**Consultation Response from KC,  
Conservation & Design****2023/93539 Land adj, Ledgard Bridge Mill, Back Station Road, Mirfield, WF14 8NZ****Outline application, including the considerations of access appearance, layout, and scale, for the erection of a six-storey building to host 76 residential apartments (C3 use) and ancillary works comprising demolition of vacant building, formation of new access, parking areas, open space and landscaping; erection of cycle and bin refuse storage structures****Date Responded: 11.02.2023****Responding Officer: S Pickles****Responding Ref:**

Project Proposed residential scheme at Ledgard Bridge, Mirfield
 Client Binks Executive Homes Ltd, Cawthorne, Barnsley S75 4EJ
 Dwg Title(17001)12_Circulation core sections B
 Scale 1:50 @ A1
 Date Jan 22

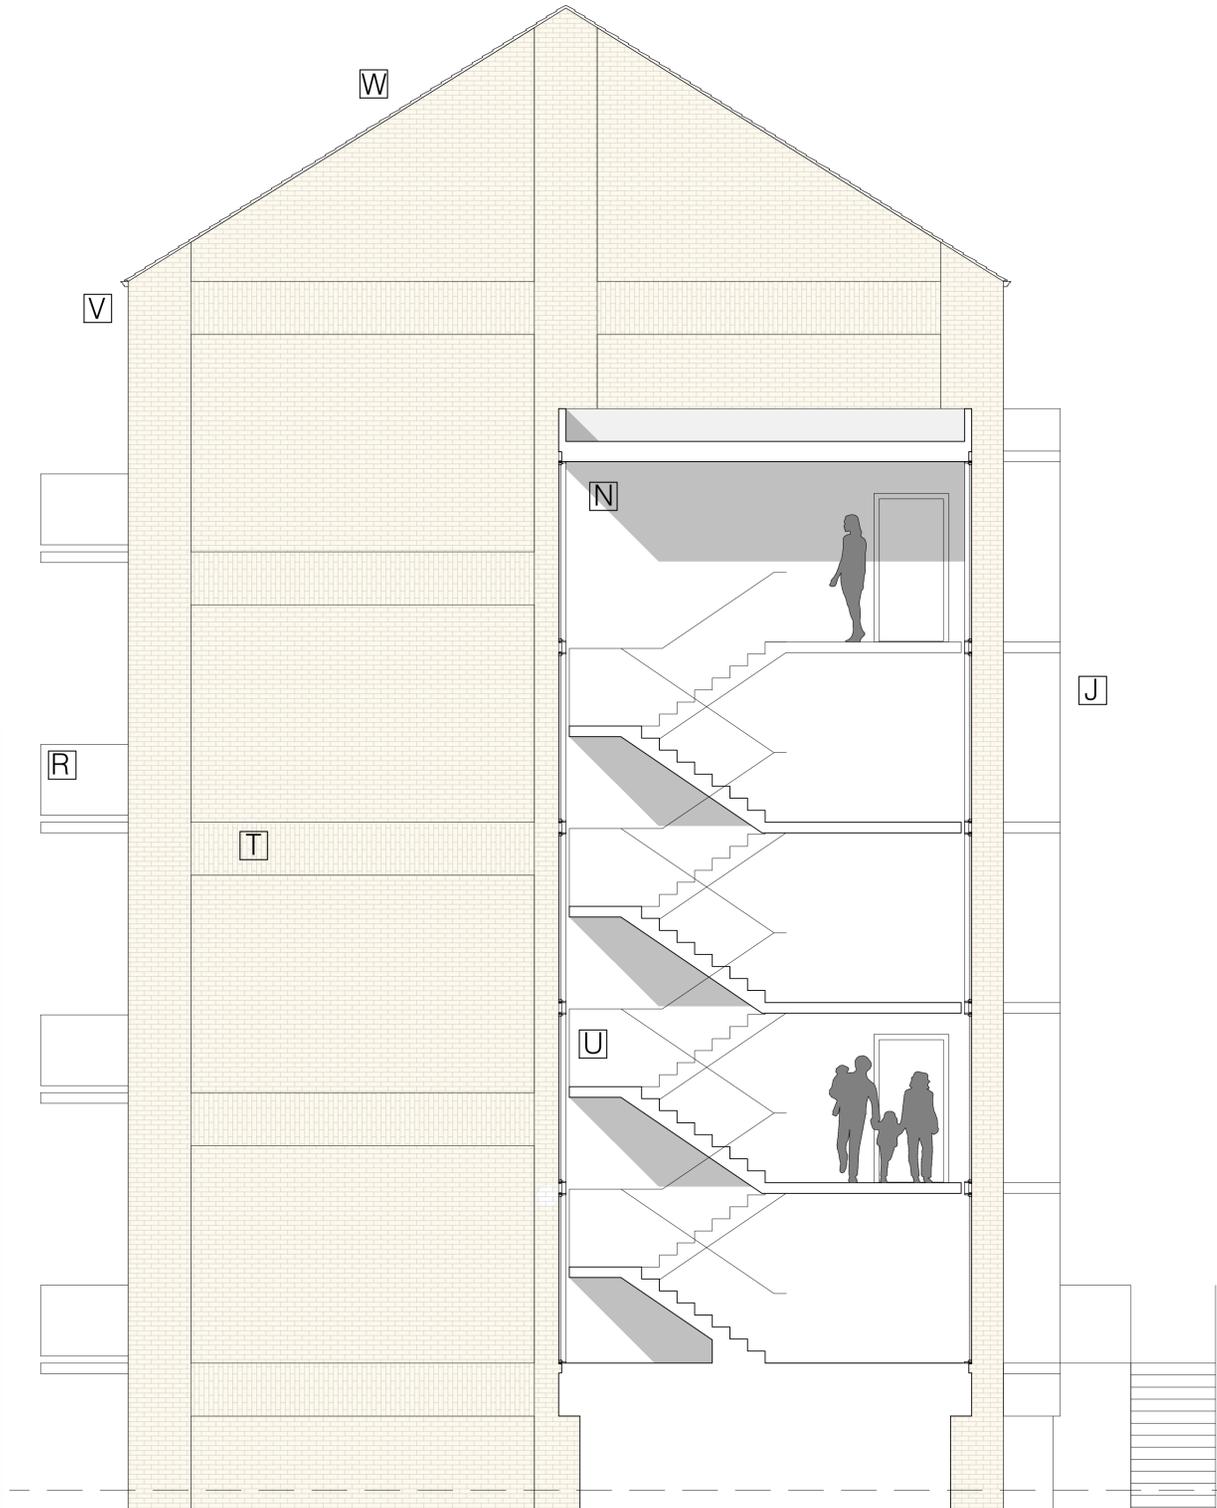
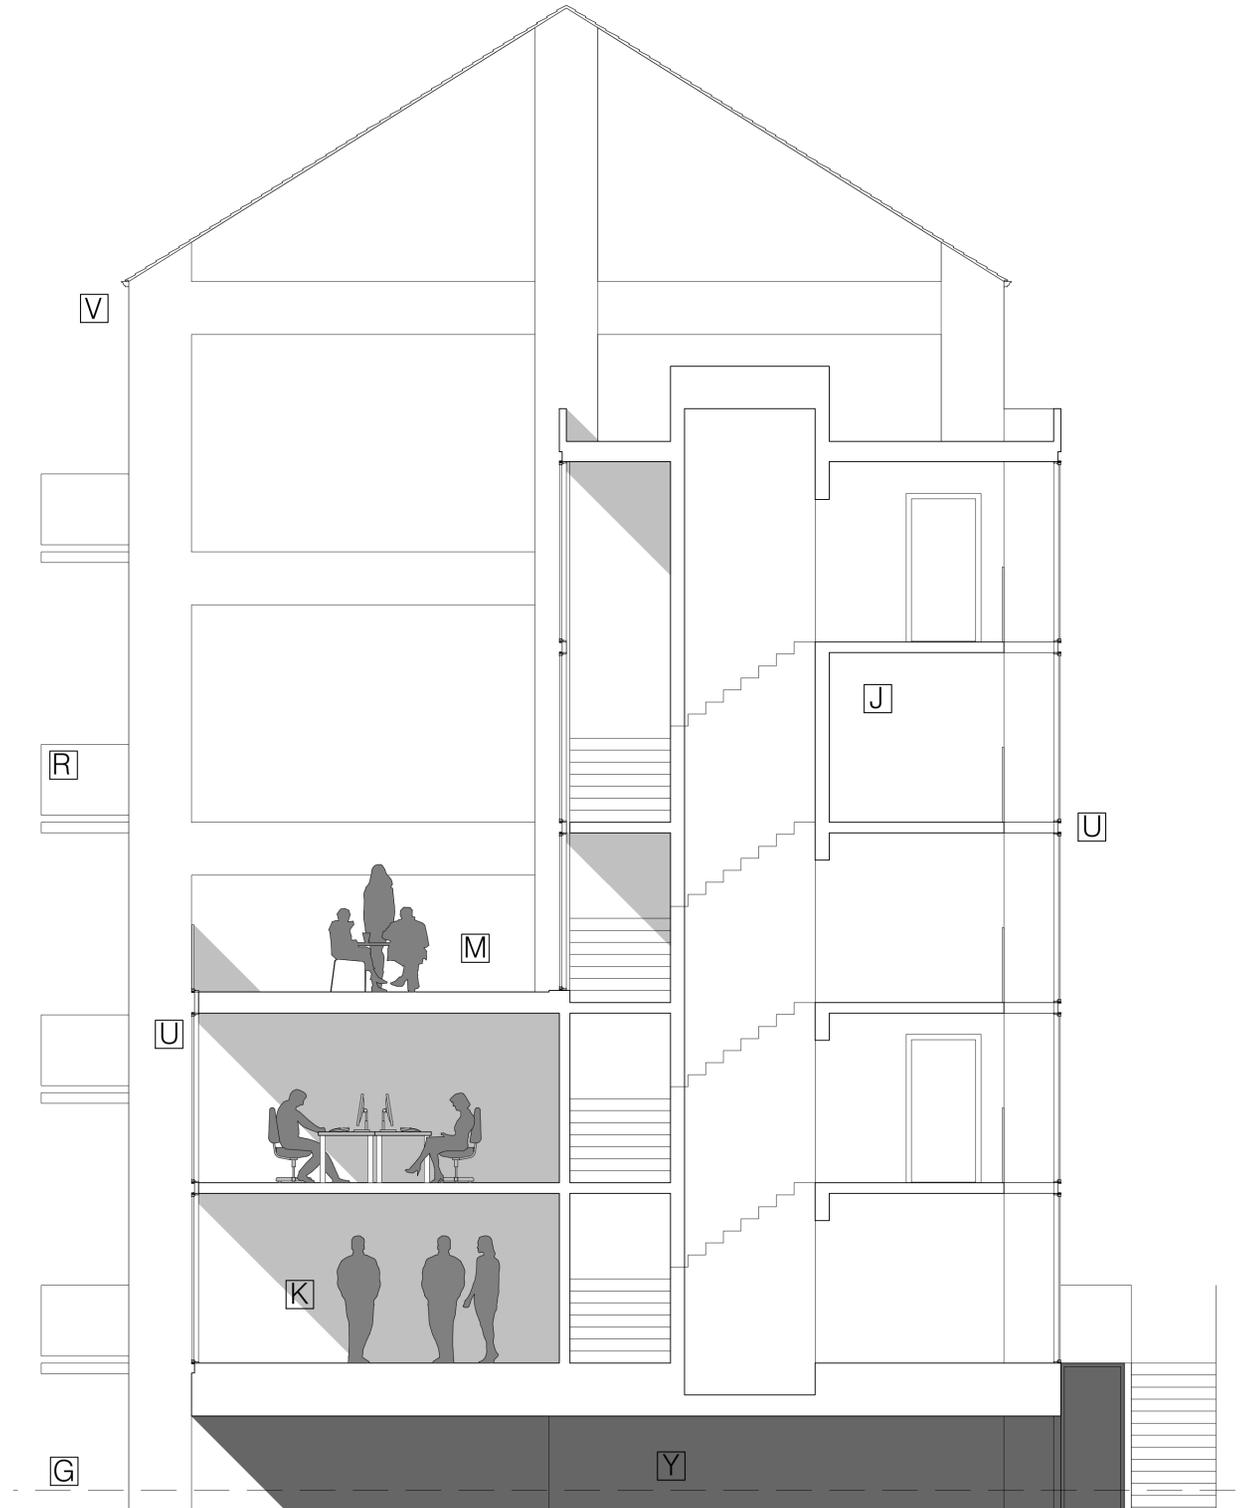
We do have concerns regarding the height and width of the proposed buildings. We consider that the building should be subservient to the historic Mill building and also reduced in width to ensure that some of the site lines and views on the historic mill are retained. We are equally not convinced by elevational treatment, which appears overly fussy and jarring with the host historic mill. We are not considering a pastiche of the historic mill, however, we would expect a design which has a better harmony with the historic mill and helps to enhance the mill rather than trying to create statement buildings. We would not support the large number of balconies on the river elevation. Juliet balconies may be appropriate, however, this would be subject to detail.

We are equally unconvinced by the proposed material palette. Within the Design and Access Statement, it sets out that it is proposed to use brick similar to a London stock brick. The statement discusses the use of natural stone, however, it suggests that the use of stone would create a bland appearance focusing on a nearby development which makes use of stone. We would not agree with this assessment, and we would advise that the main elevational materials should be natural stone, either pitch or rock-faced. Elements of brick could be incorporated, as there is evidence of this within the surrounding area, however, the brick should be more of a traditional red brick. This could be used on end or more discreet elevations. It could also be used as a means of breaking up the elevations.
